**A122 LOWER THAMES CROSSING (REF: TR010032)
DEADLINE 6 SUBMISSION**

CHEALE GROUP LIMITED – RR20035735

MULBERRY STRATEGIC LAND LIMITED – AFFECTED PARTY REFERENCE: AP1581

Plate 83

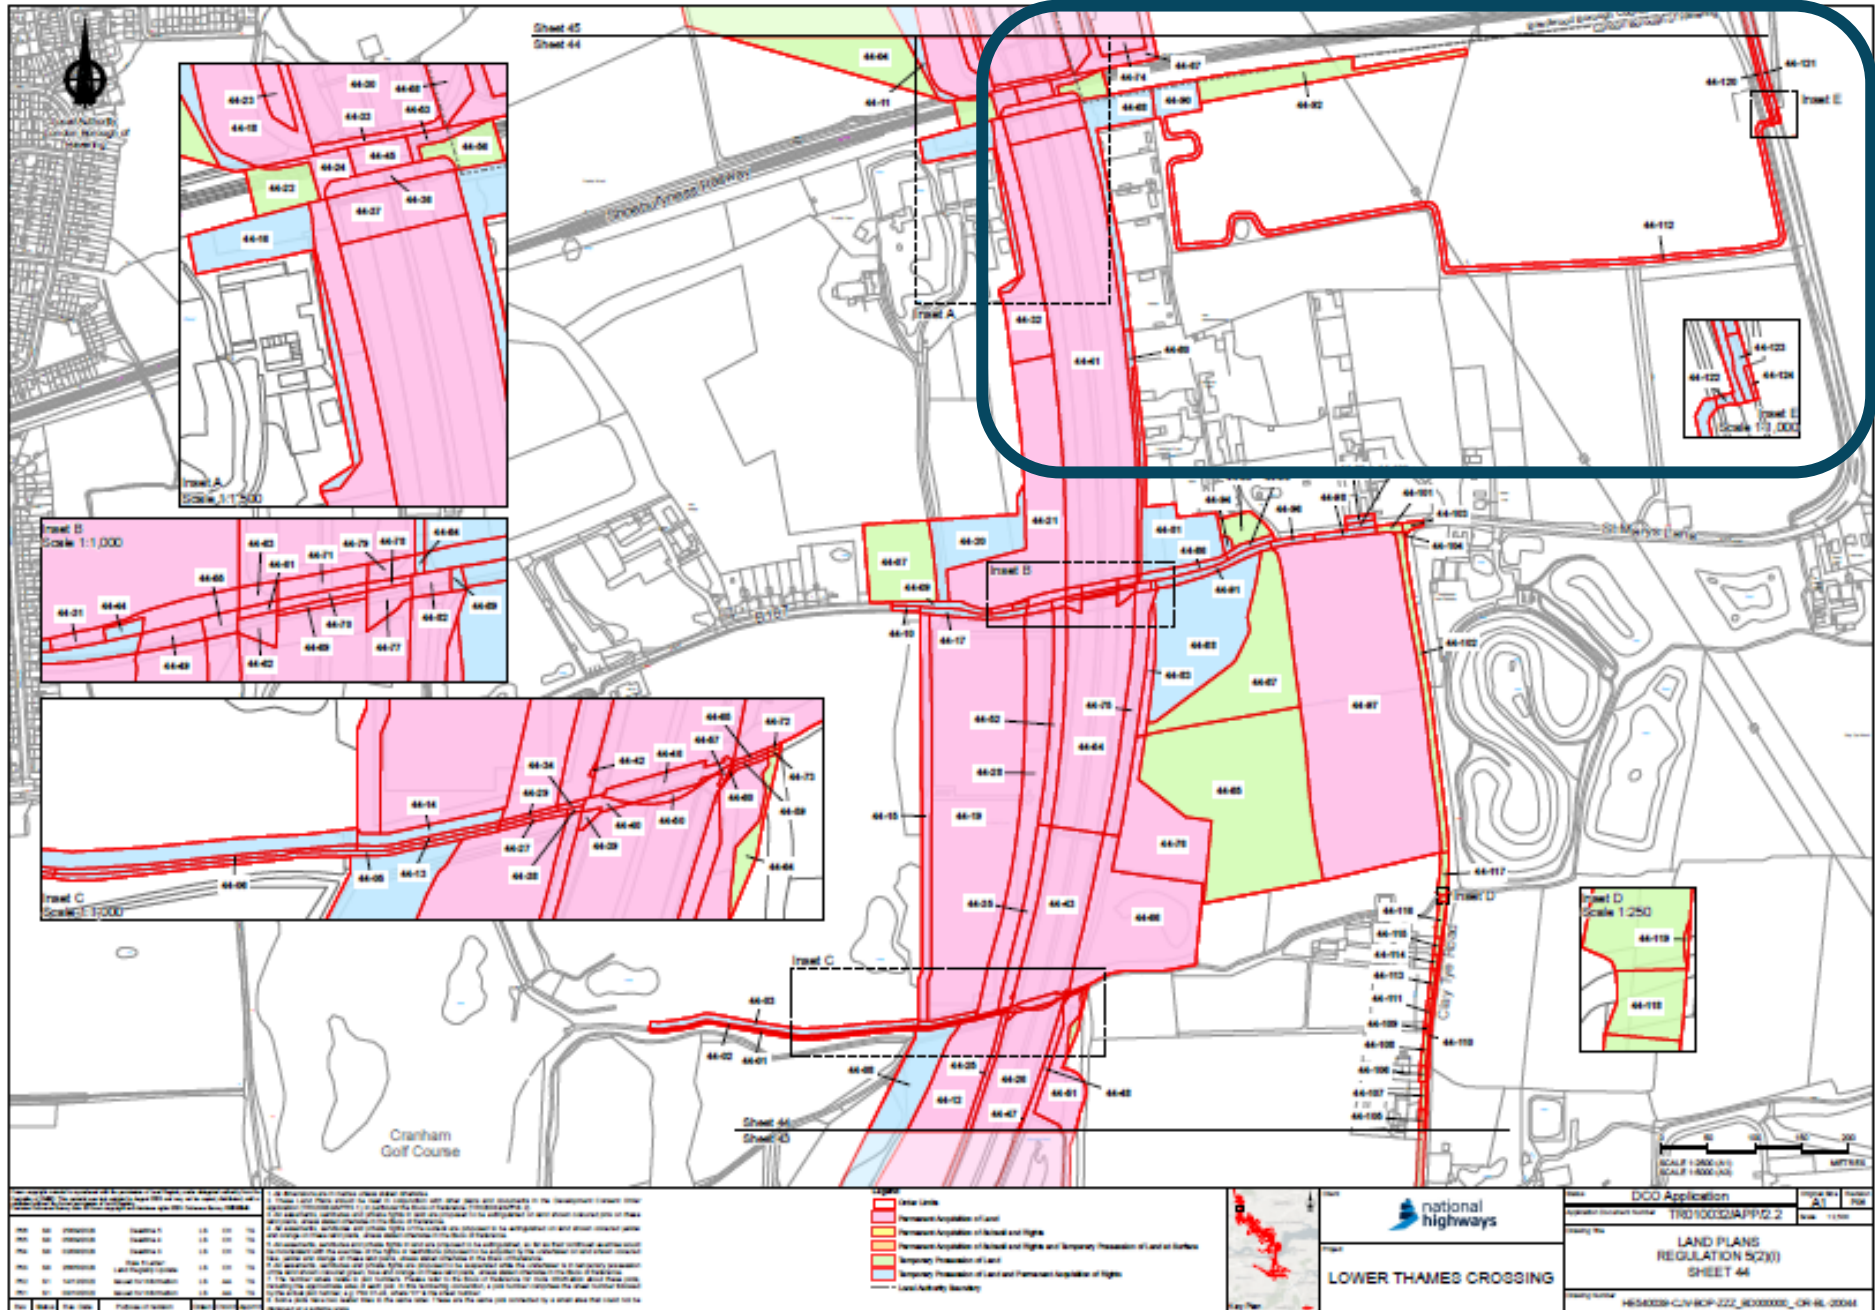
Plates 82 & 83	<p>Plates 82 and 83 show the Applicant's proposals for utilities works areas in Plot 44-90 and 44-92 together with a route of access (under temporary possession with permanent rights) affects land owned by Cheale Group Limited.</p> <p>Our clients total land area in this location is as edged on the outline plan in Plate 84.</p> <p>Mulberry Strategic Land Ltd hold an option over this land for the promotion of alternative commercial use.</p>

Plate 84

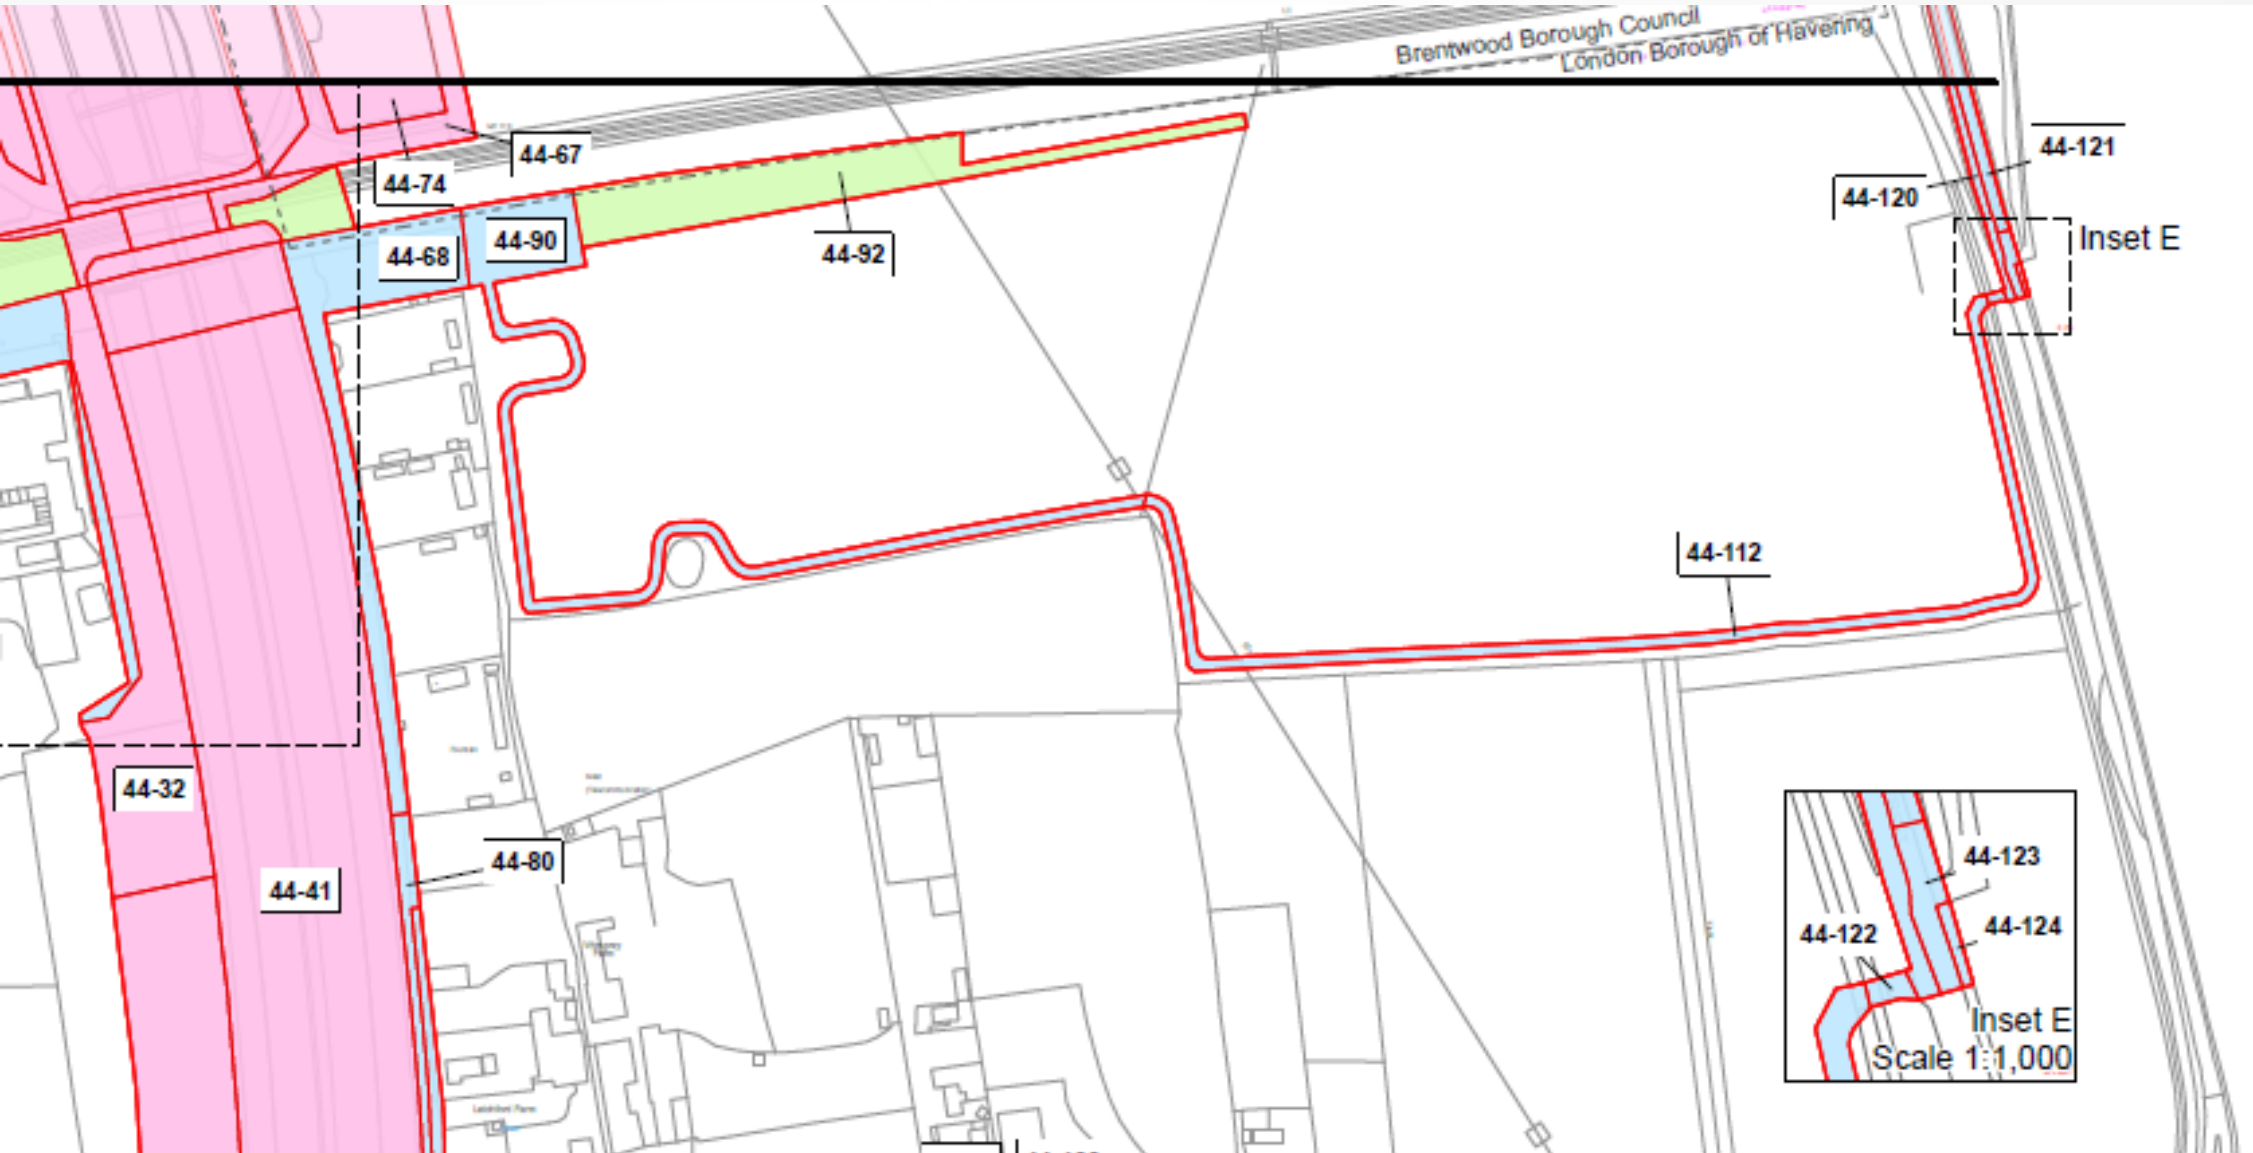
Plate 84	<p>Plate 84 shows a broad draft masterplan of commercial development which remains subject to further technical work and submission to Havering Borough Council through their Local Plan review.</p> <p>The Applicant's proposed route of access rights follows the yellow line.</p> <p>Our submission is a request to the Applicant to provide a legally binding commitment to a lift and shift provision with the Applicant and relevant statutory undertaker that the proposed route of access can reconfigured as part of our client's emerging development masterplan – for example, in the case of the current draft masterplan, along the route coloured blue.</p>
-----------------	---
